Ask for:	Erika Davies
Telephone:	01832 742207
Planning Services	Planning.enc@northnorthants.gov.uk
Our Ref:	NE/21/01069/FUL
Your Ref:	PP-09997866
Date:	13 July 2021

Proposal : **Single storey ancillary accomodation to replace existing single garage. at Pond Yard 32 Back Lane Collyweston Northamptonshire PE9 3PJ .**

**ROOF PLAN**  
SCALE - 1:100

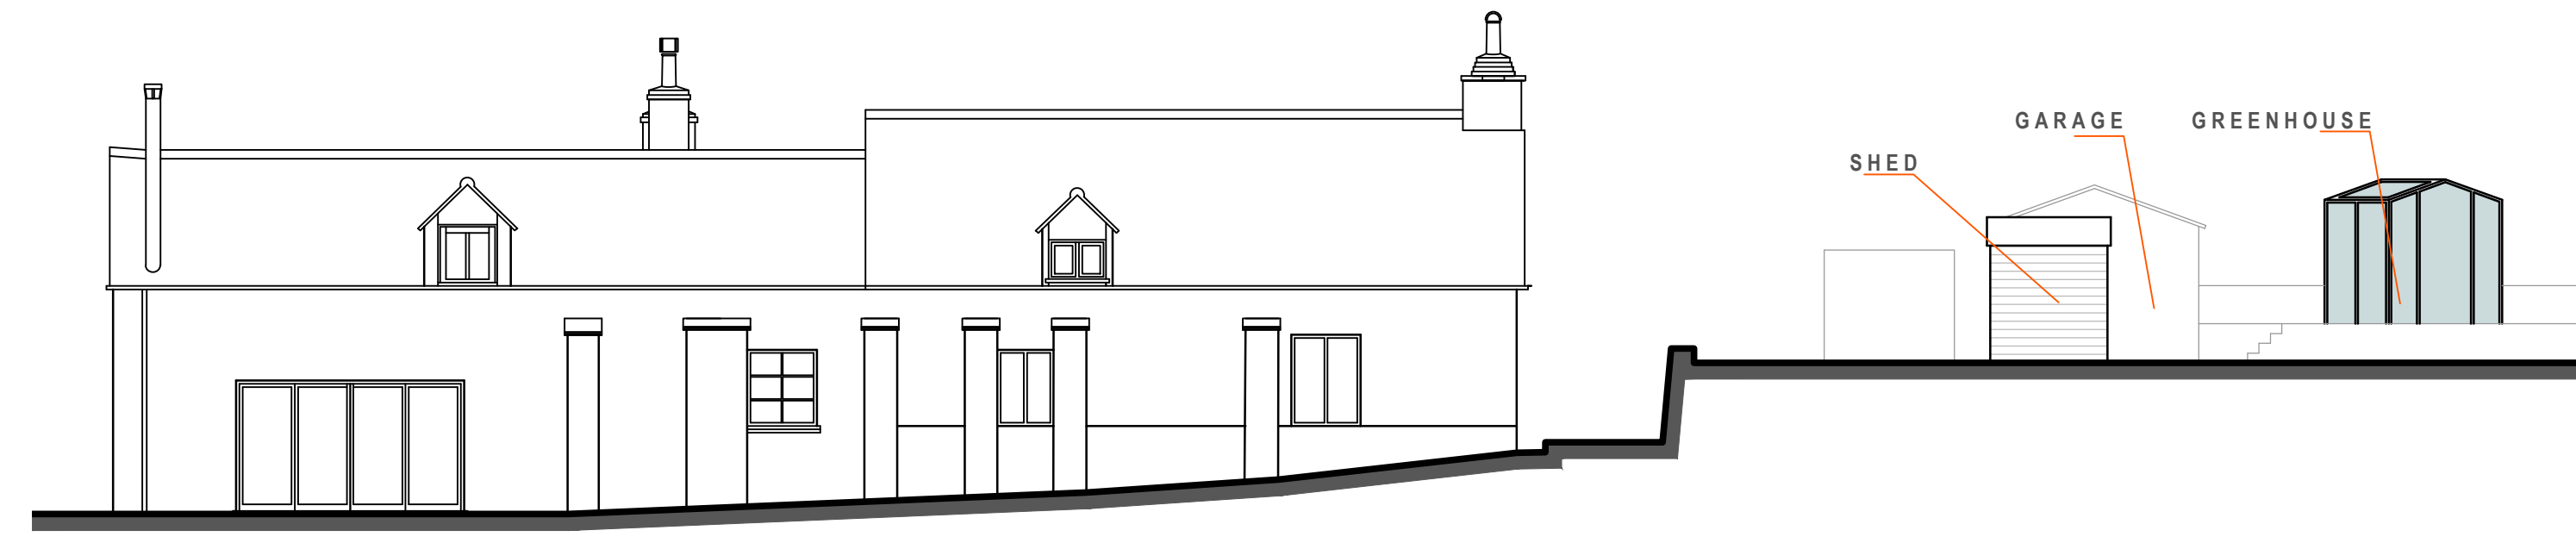
Please provide amended drawings including all relevant dimensions of the proposal:

- Dimensions for the existing and proposed floor plan
- Dimensions for the existing and proposed elevations annotated with all height dimensions
